7<sup>th</sup> February 2019

Our Ref: 176416

**RE: Development Application – Building D14 Redevelopment UNSW (SSD 9606)**

Figure 4: Proposed Servicing Solution

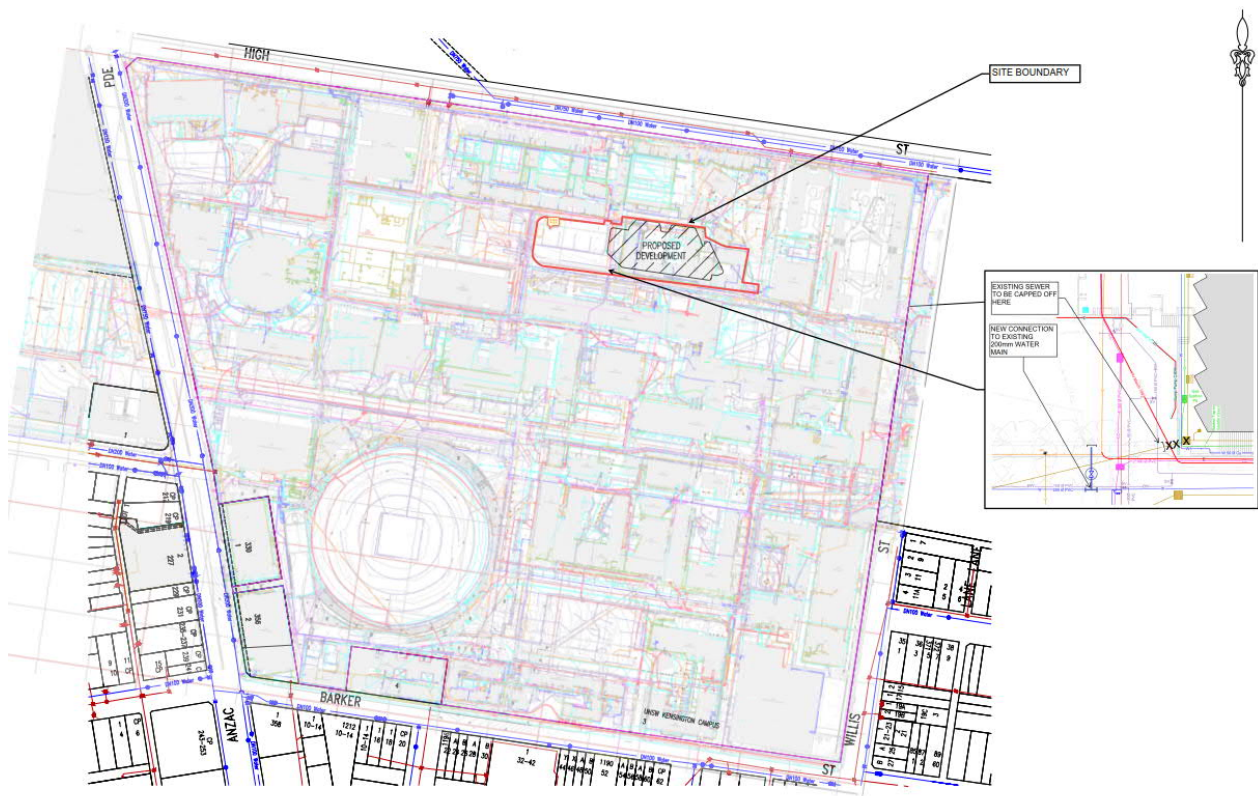
- The proposed development site is under Waverly Water Supply Zone. The redevelopment site is close to High Street, hence will be serviced by the watermain in High Street.
- The GFA of the development is 15,010m<sup>2</sup>. Potable water demand of the development was not provided by developer. Considering the size of the development, the existing watermains in High Street will need to be upsized to service the development.
- The developer is advised to engage a hydraulic consultant to identify the size and length of the to be upsized watermain.

- The proposed development site is under Malabar Sewerage System. The redevelopment site is close to High Street, hence will be serviced by sewer in High Street.
- The GFA of the development is 15,010m<sup>2</sup>. Sewage discharge of the development was not provided by developer. Considering the size of the development, the existing sewer in High Street will need to be upsized to service the development.
- The developer is advised to engage a hydraulic consultant to identify the size and length of the to be upsized sewer.
